Re: FP/207/18/HH

Single and two storey rear extension along with new dormer roof window

29 Roundle Avenue, Felpham PO22 8LL

PROPOSED ROOF PLAN 1:100

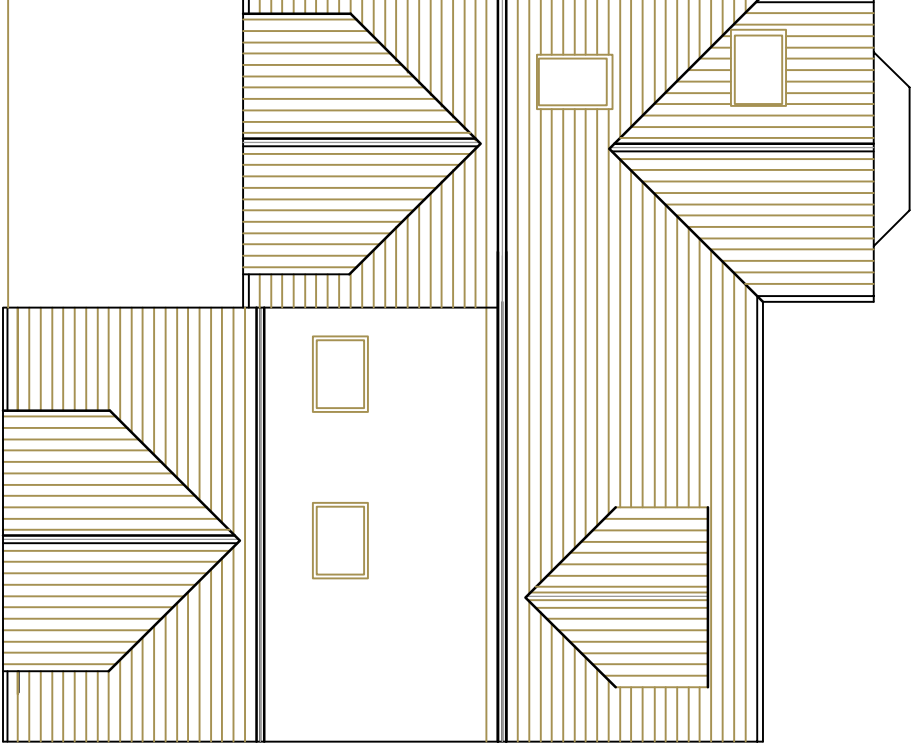
The proposed plan changes the current hipped end which is next to our property to a gable end. Also there are two dormer windows being added to the roof at the rear of the property. These are very large, starting just below the roof ridge and protrude so the front is almost flush with the existing rear elevation. The extensive width of these dormer windows means that the one closest to us will start only slightly in from the new gable end wall.

- The proposed development would result in two gable ends which is in contrast to all the other bungalows in the vicinity and also results in the loss of an important visual gap
- The proposal introduces a flat roof section on one side at the height of the current ridge which would be visible from the road and alien to the area
- The contrast with the surrounding roofs and the accumulation of the additions would exacerbate the proposal's harmful impact
- The major reconfiguration would be at odds with the existing pattern of development and the qualities which contribute to its local distinctiveness.

DRAWING  
**PROPOSED  
ELEVATIONS**  
DRAWING No  
**259/05**  
SCALE 1:100  
DATE 14/04/2018  
REVISION  
**A**  
DRAWN  
CHECKED  
LA

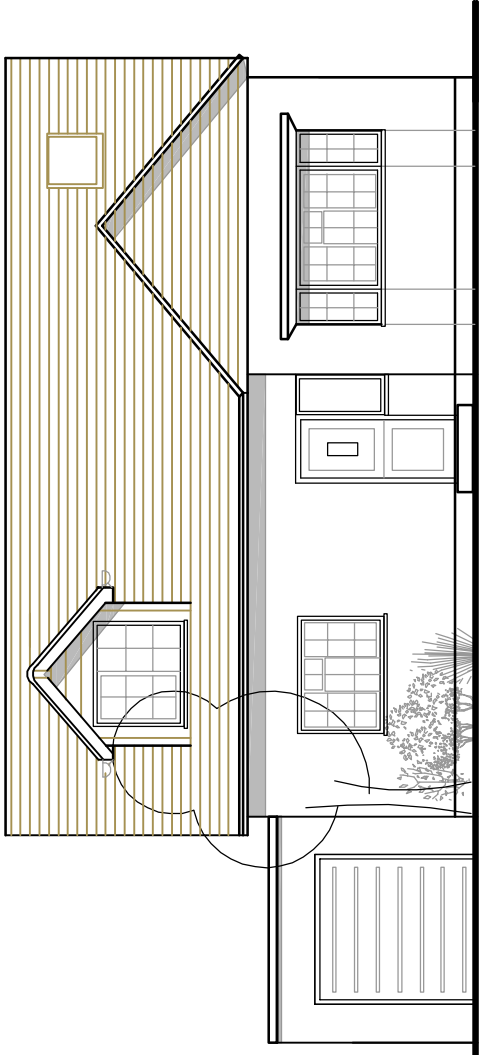
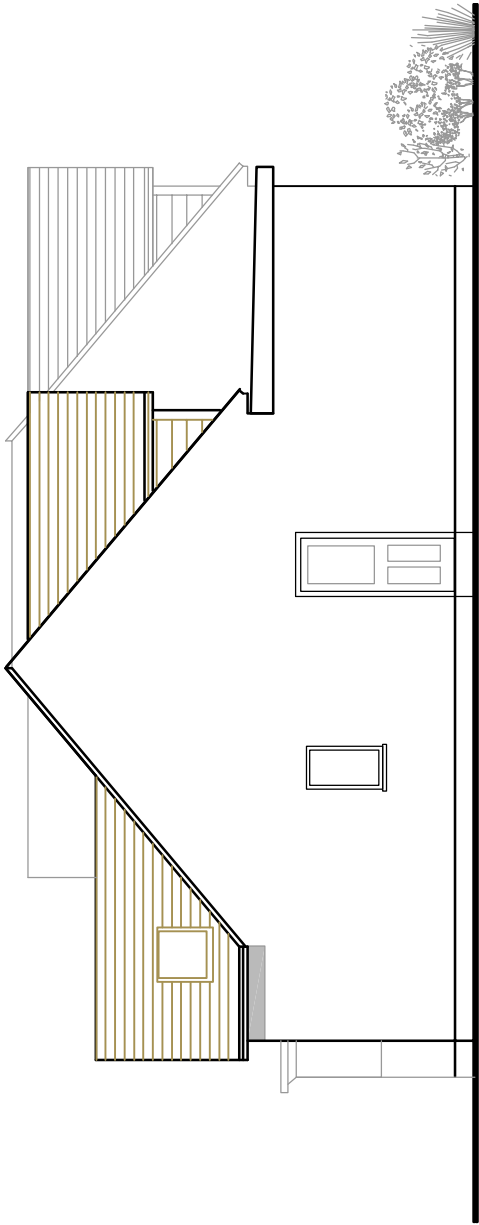
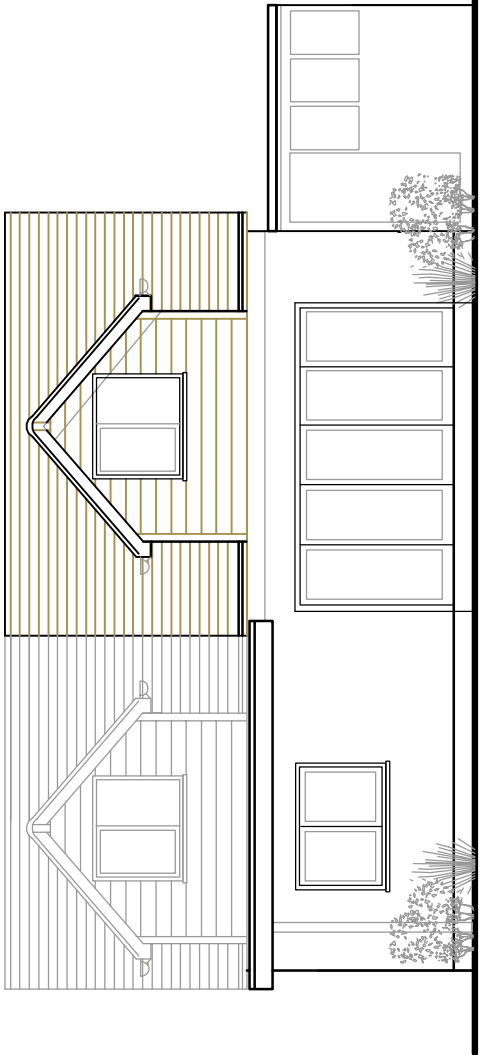
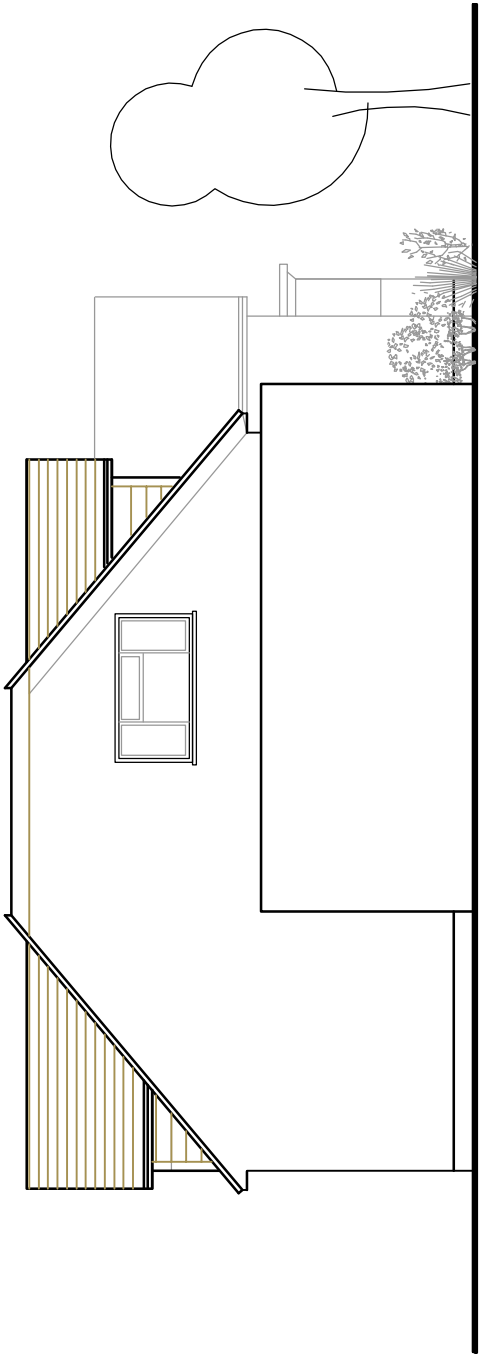
Our property is set 2.3 metres further forward to the south- east and there is only a distance of 1.8 metres between the wall of no. 29 and the wall of our property. Our main objection is that in view of this the first floor extension would be overbearing from our point of view and there would be loss of outlook and also loss of light.

The current gap created by the hipped end at number 29 would be lost and this together with the large dormer window would have an oppressive impact. It would reduce the enjoyment of our rear garden, looming large over our patio and create a sense of enclosure in view of its height, depth and bulk resulting in a serious loss of outlook.

The change from the current hipped end to a gable end together with the large dormer window would also restrict light into our property. This includes our kitchen which is at the rear of our property and also a side window to our lounge, which whilst being secondary to a window at the front, gives valuable light after midday when the sun moves round. We also have a rooflight which provides valuable light in the rear of the bedroom on the south west side of our property which would be affected by the change of the hipped roof to a gable end.
